RE: BALDWIN STORAGE BUILDING PHASE 1 (C-18/D18)
(5800 Carmel NE)
ENGINEERS CERTIFICATION FOR CERTIFICATE OF OCCUPANCY
ENGINEERS STAMP DATED 2/20/2002
ENGINEERS CERTIFICATION DATED 8/26/2002

**RE: BALDWIN STORAGE BLDG. PHASE 1 (C-18/D18)
ENGINEERS CERTIFICATION FOR CERTIFICATE OF OCCUPANCY
ENGINEERS STAMP DATED 2/20/2002
ENGINEERS CERTIFICATION DATED 7/25/2002**

Re: Baldwin Storage Building (Holly Avenue NE) Grading & Drainage Plan, Engineer's stamp dated 12-18-01 (C18/D18)

Re: TCL Submittal for Building Permit Approval for
Baldwin Storage Building, [C18 / D18]
6001 Holly Avenue N.E.
Architect's Stamp Dated 12/12/01

C18-D18 1/2

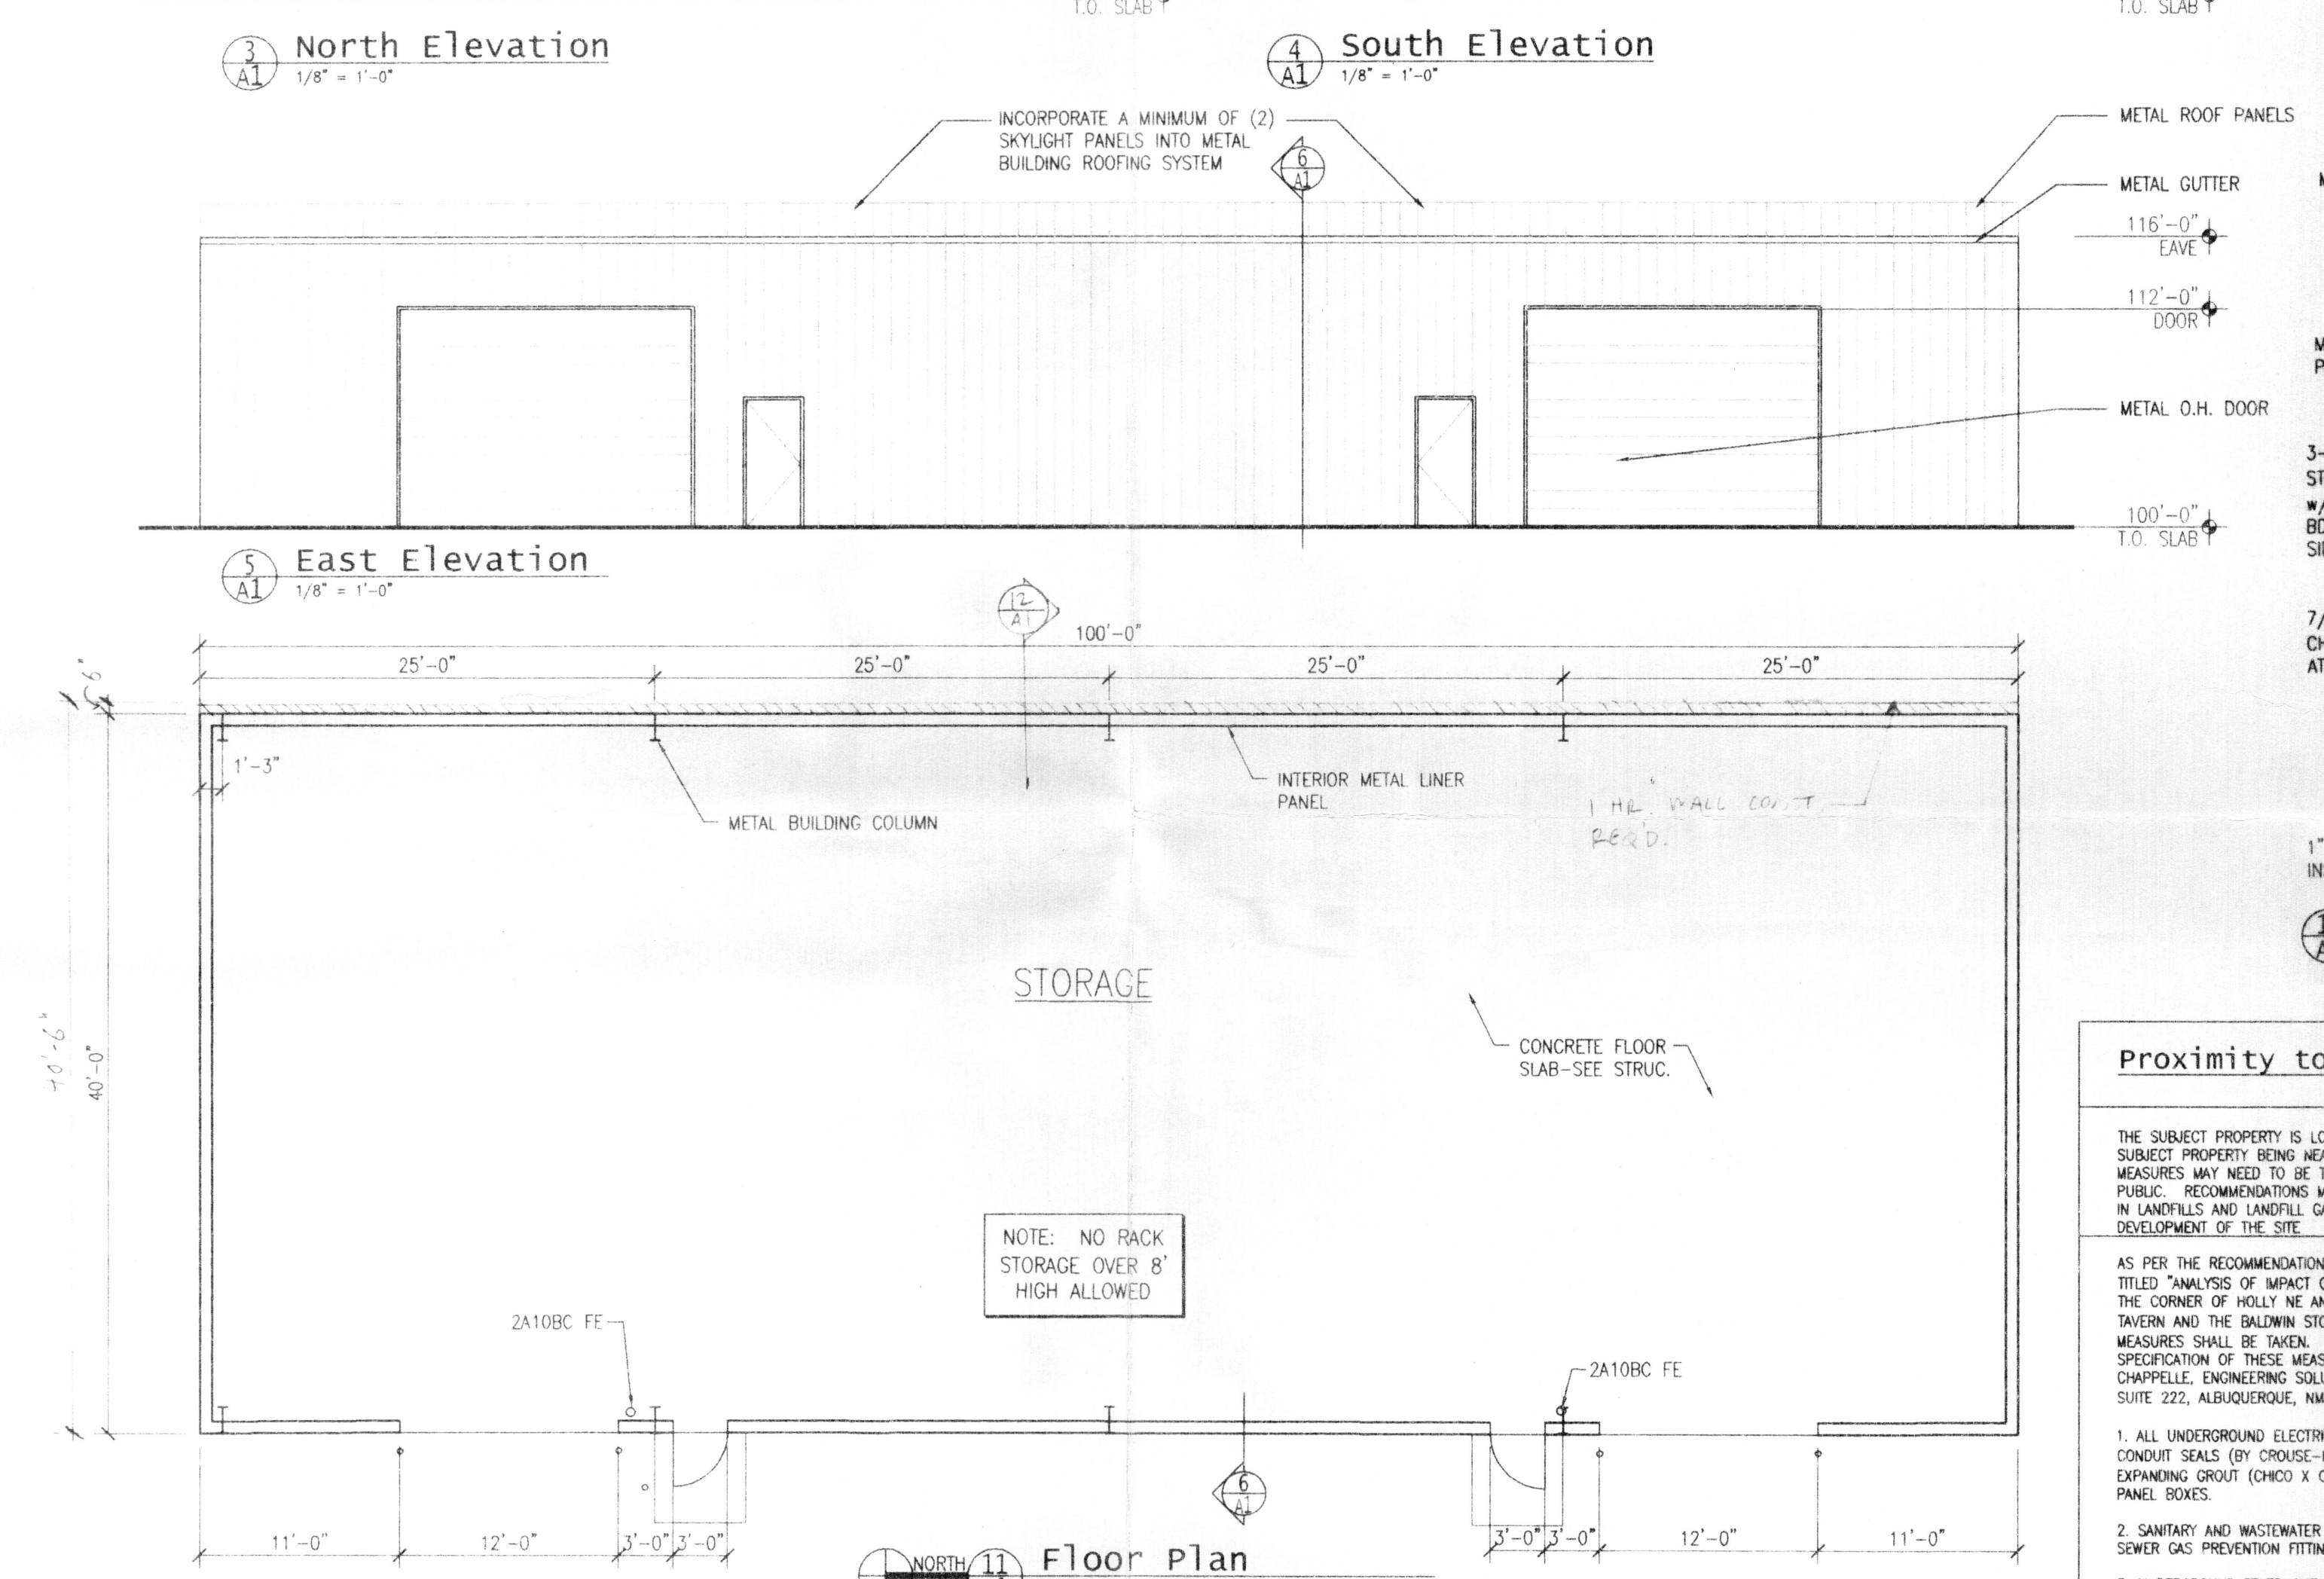
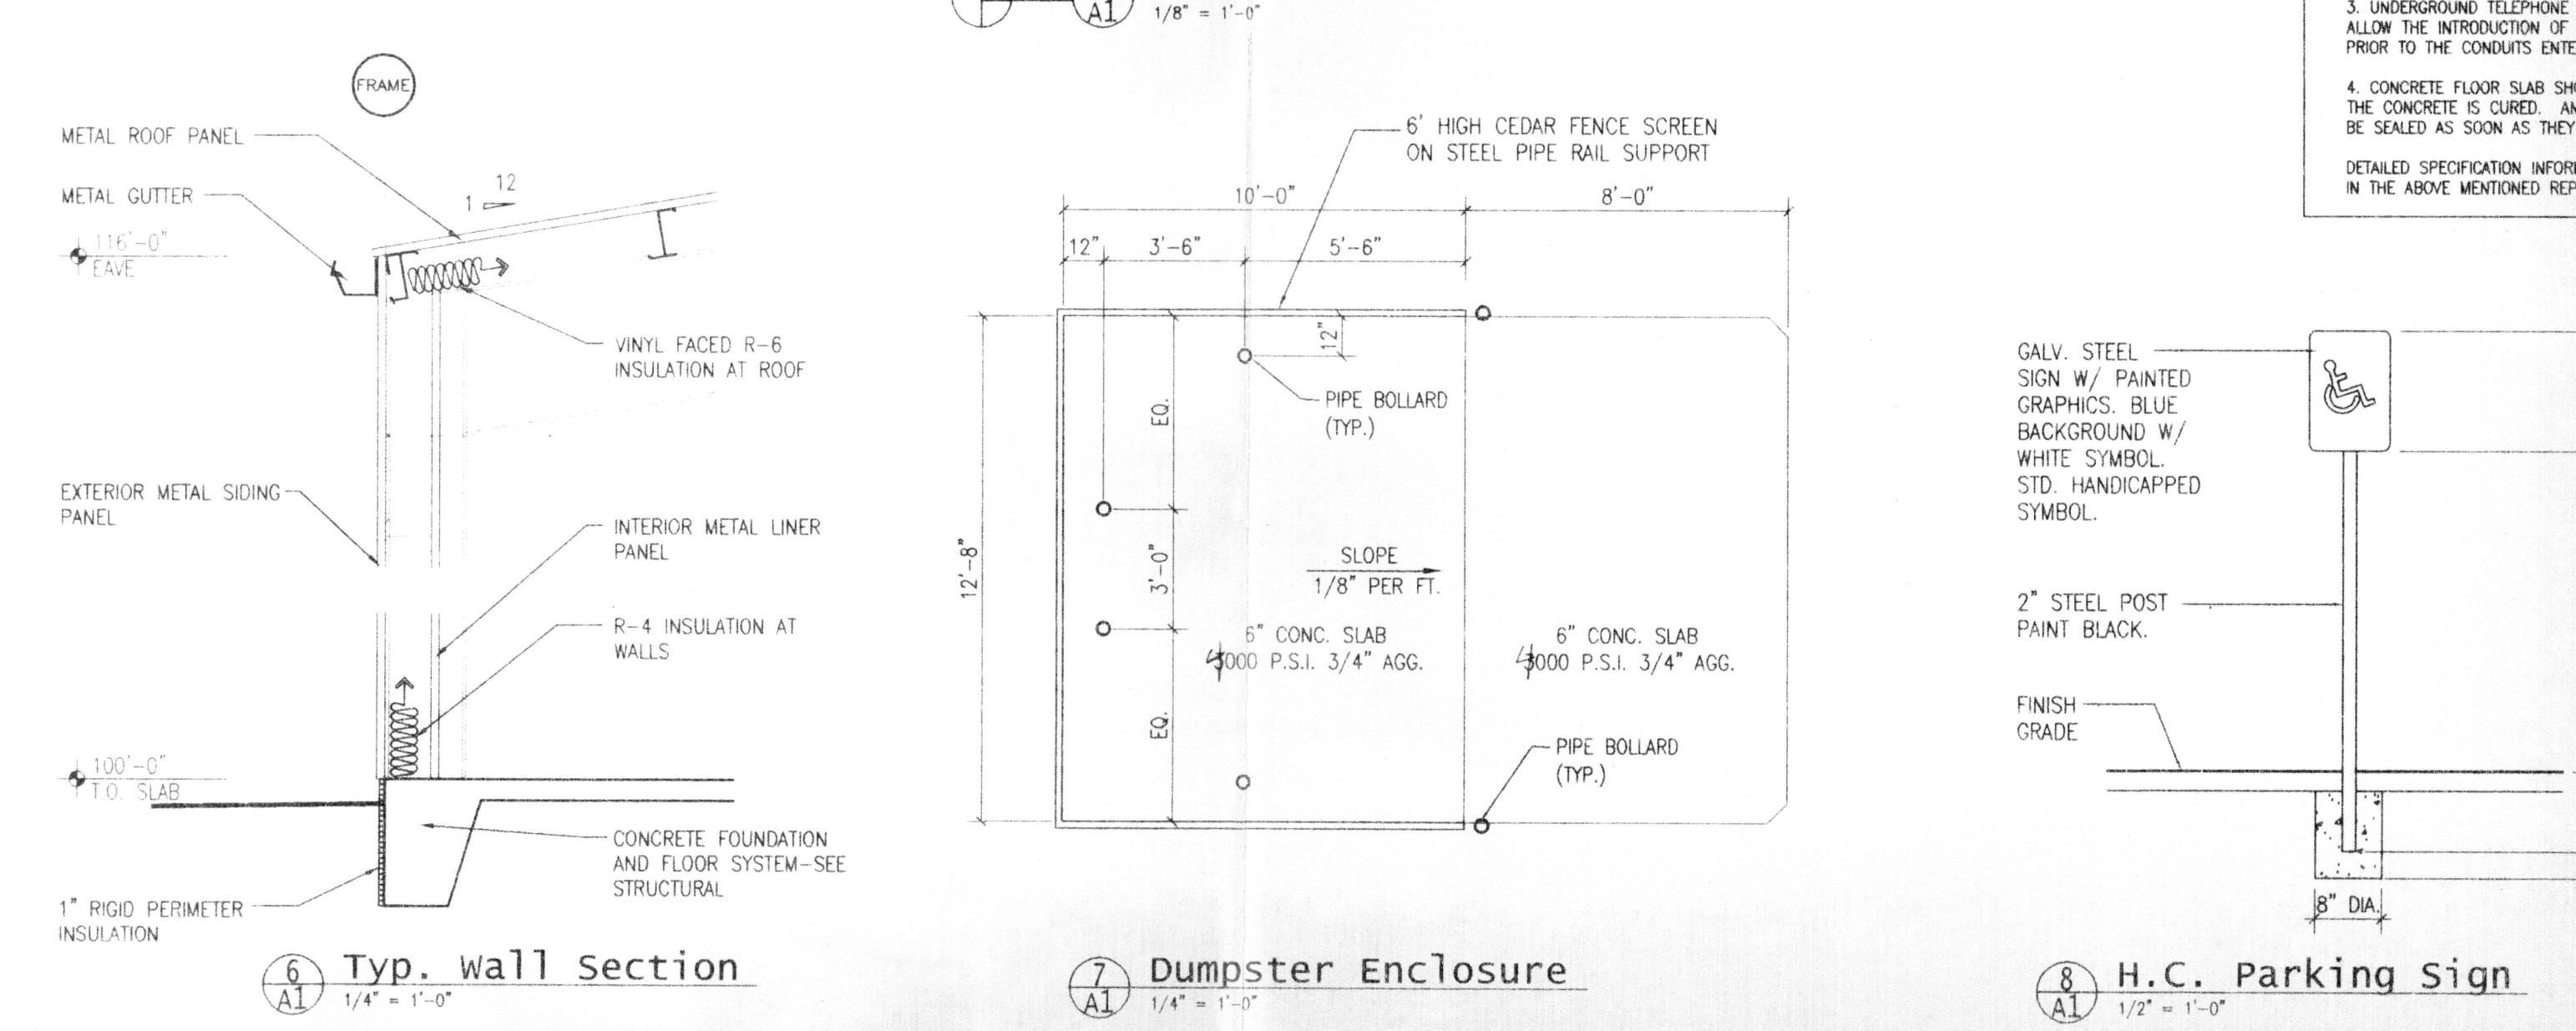
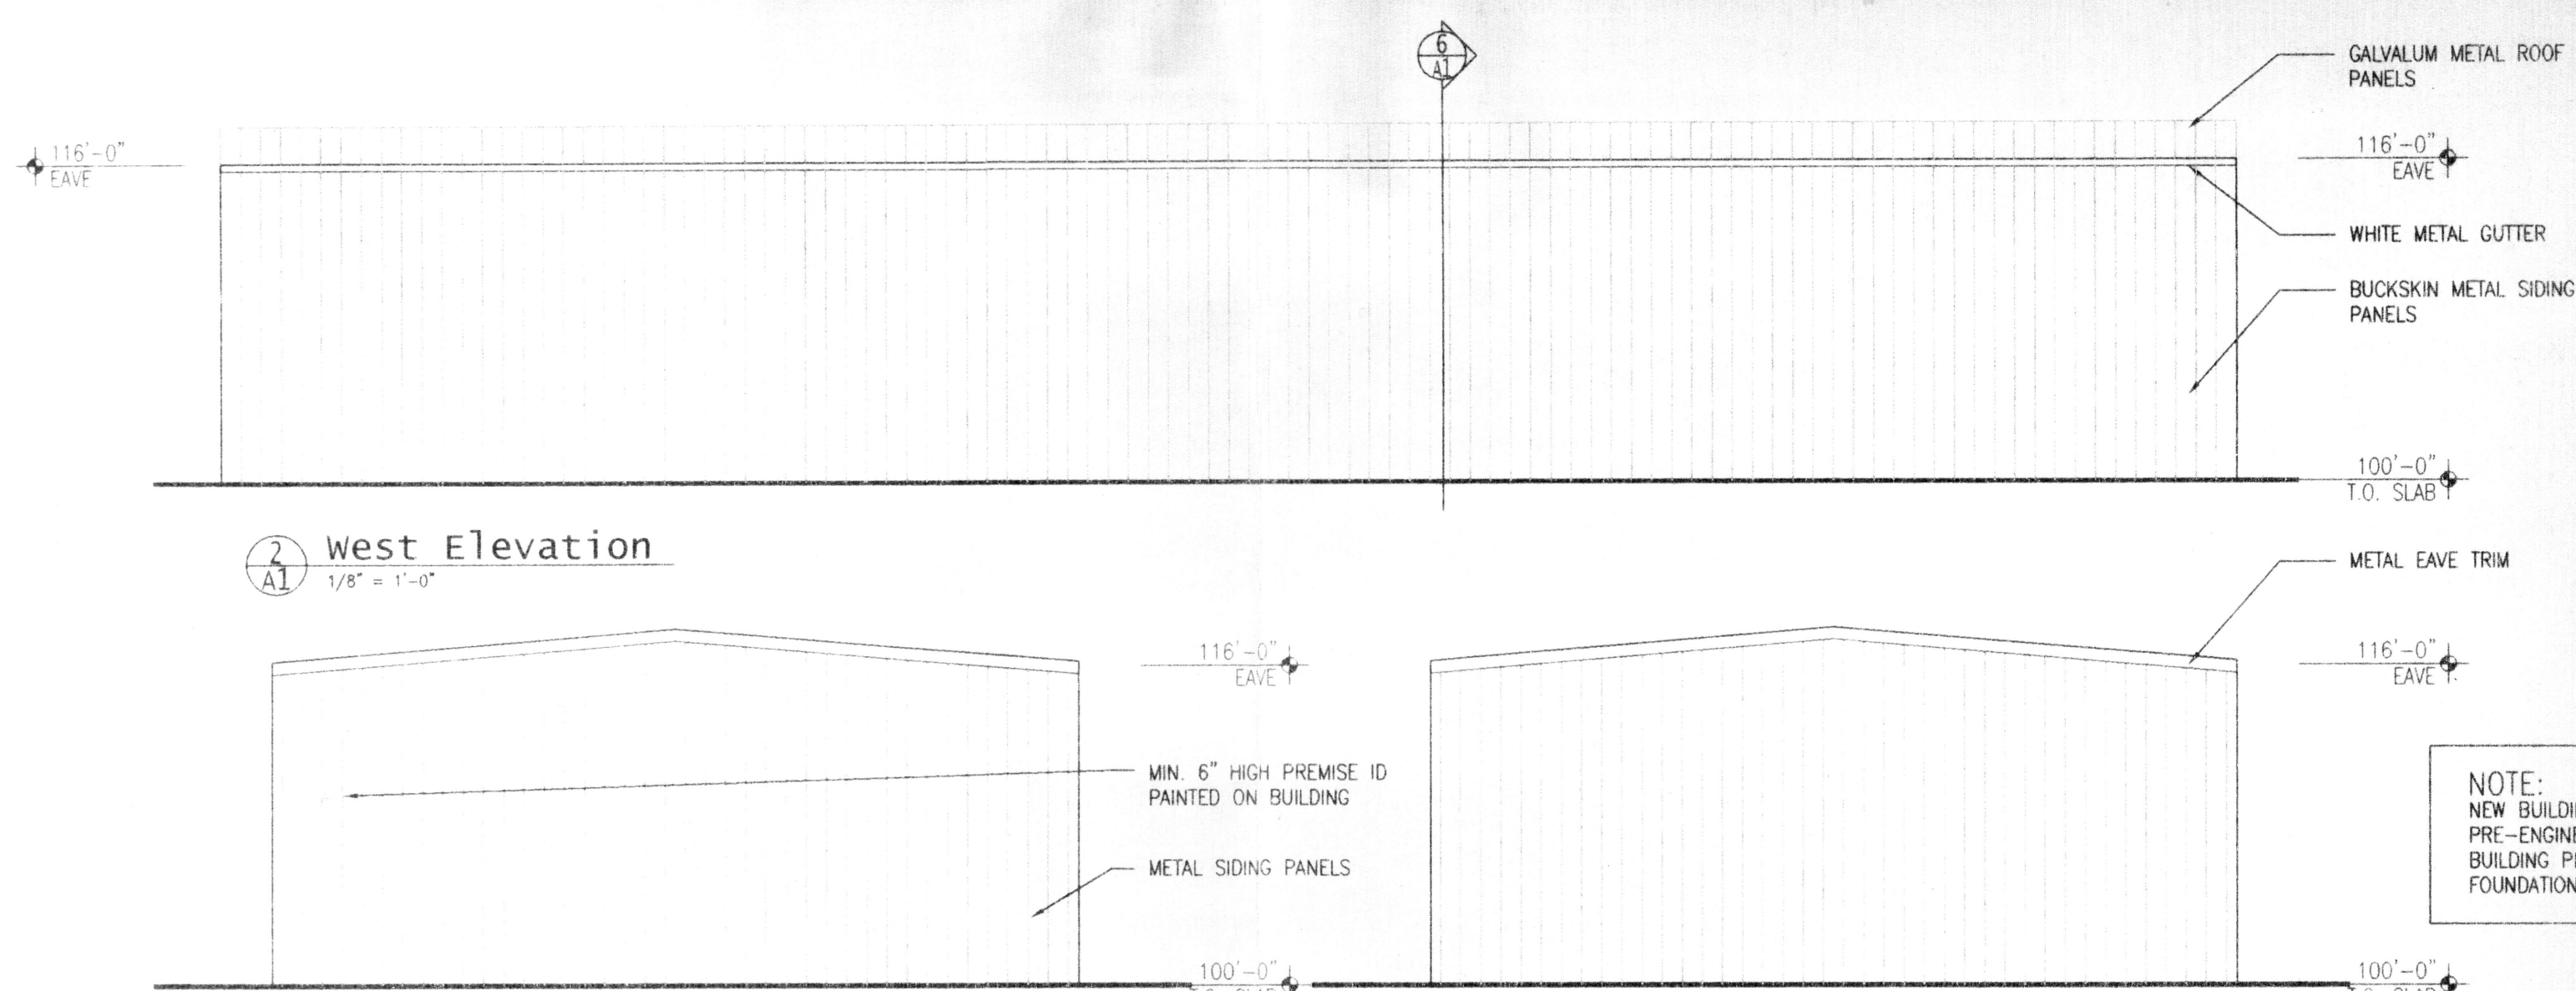
The drive aisle of the typical parking area should line up with the driveway for smooth traffic flow. If it does not, the parking stall group needs to be moved away from that driveway to allow a vehicle to wait at the back of the sidewalk with vehicles behind it smoothly flowing to the drivepad without hindering incoming traffic. Stripe the area shown in broad red linework.

Trucks using the overhead doors for this site will need to access the doors in one of two ways as shown. This requires sufficient area to approach the doors and trucks loading/unloading must not be parked in the drive aisle used by vehicles parking in the parking area. The path of all vehicles using this site more than once a month must be paved with asphalt.
